Please ask for: Ms Iqraa Malik
Email: iqraa.malik@terraquest.co.uk
Telephone: 01212341390
Our Ref: EP/165/20/HH
Your Ref:
Date: 8th January 2021

Application for Planning Permission for Works or Extension to a Dwelling

Development: Erection of single storey rear extension
Location: 34 Russells Close East Preston BN16 1BT

Drawing Title: Location Plan and Site / Block Plans

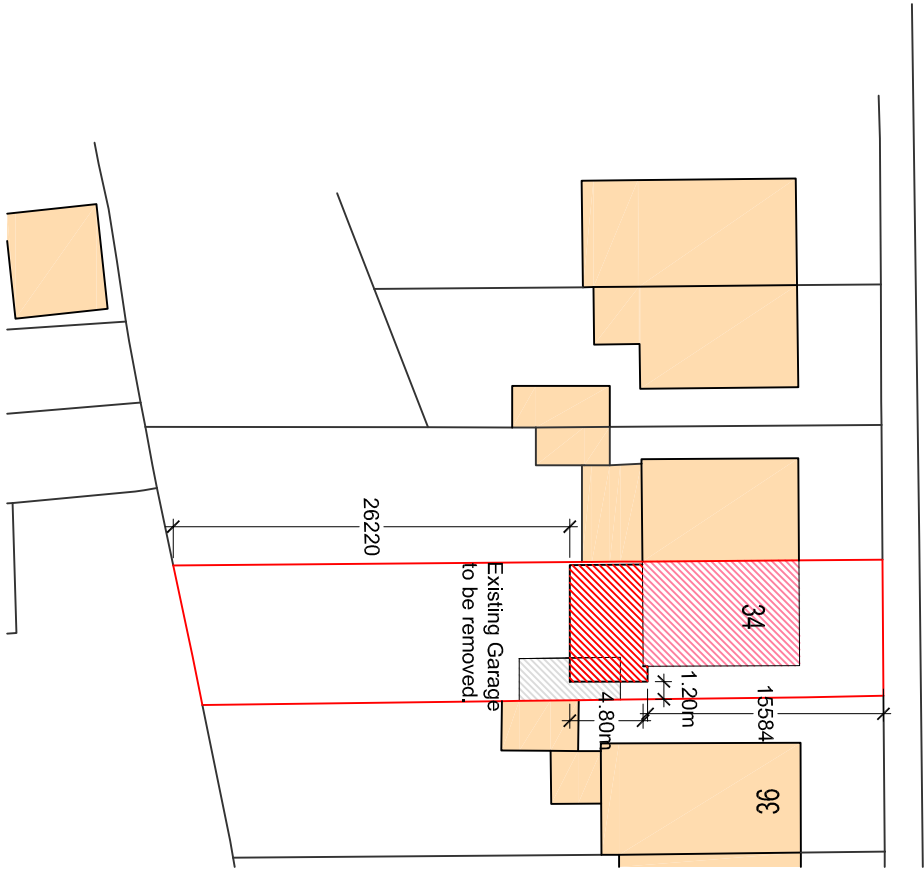
Block Plan

You are required to have dimensions from the proposed extension(s) to all site boundaries. Please amend.

Revision	Date	Description
Client:		
Mr & Mrs D. Clarke, 34 Russells Close, BN16 1BT		
Project:		
Replace and extend conservatory		
Drawing Title:		
Proposed Layout Plan & Elevations.		
Scale:	Date:	Drawn By:
1:100	30/05/2019	BE
Drawing Number:		Revision:
1330/003 - A		B

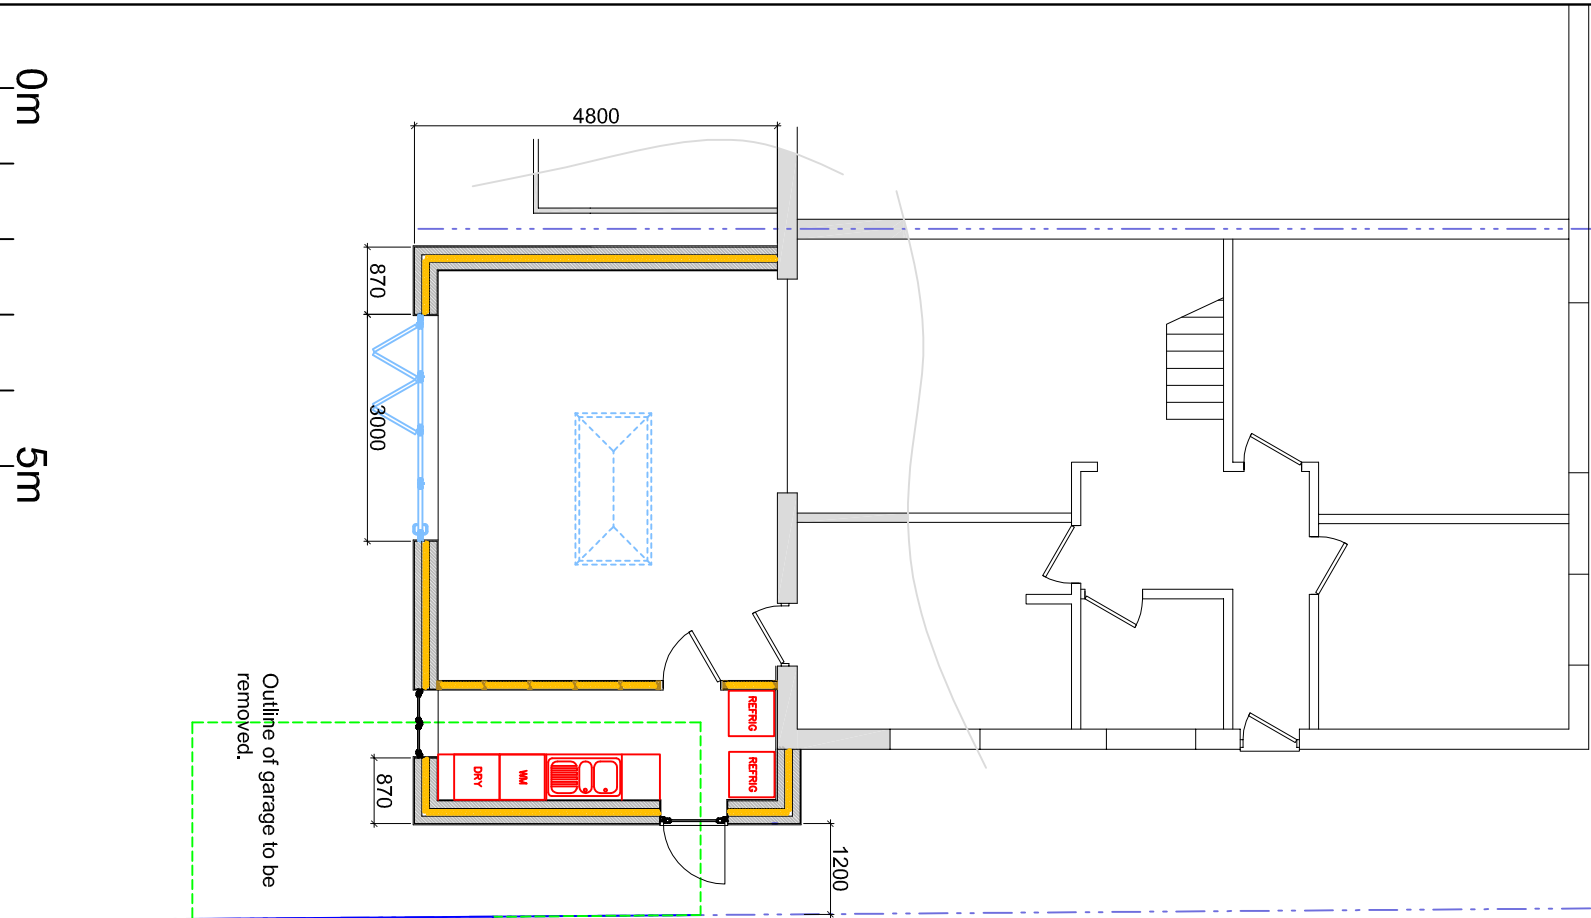
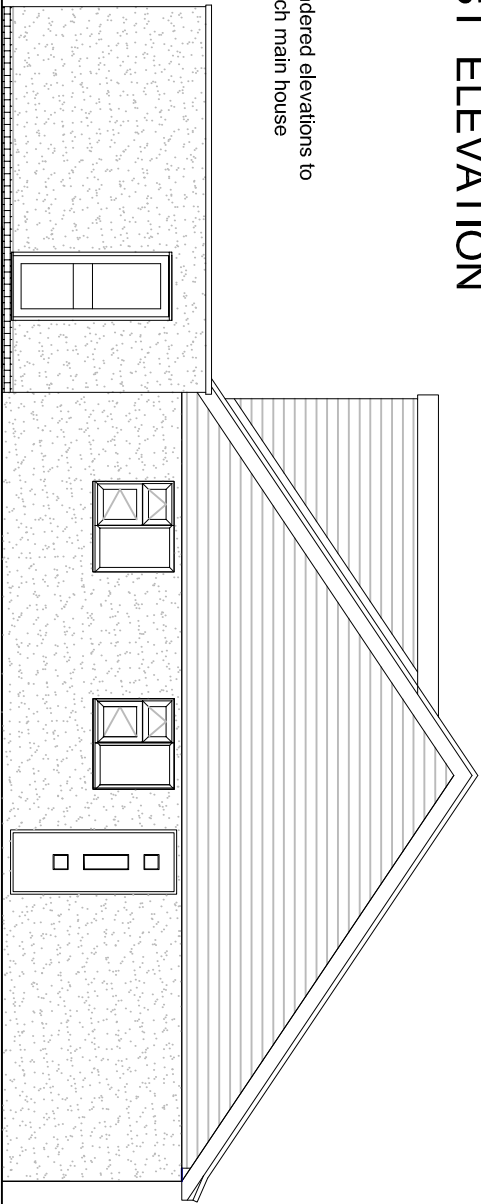
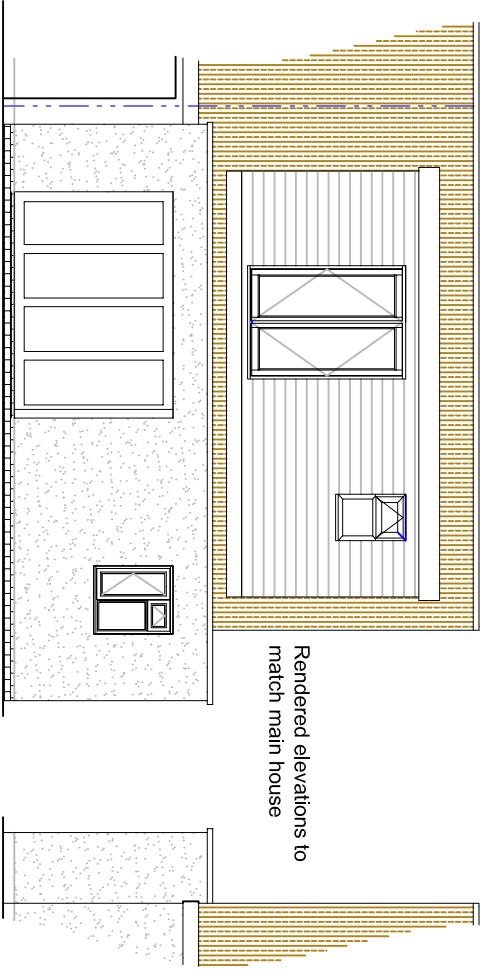
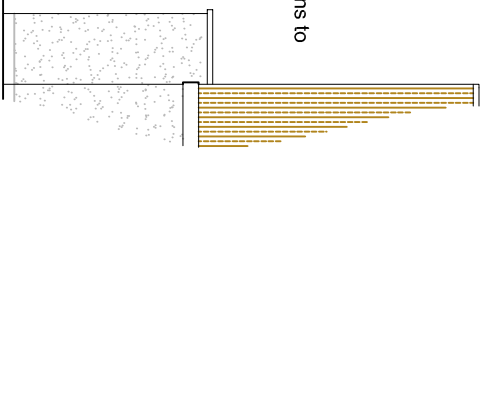
All Plans

All plans and elevations require a scale. Please amend.
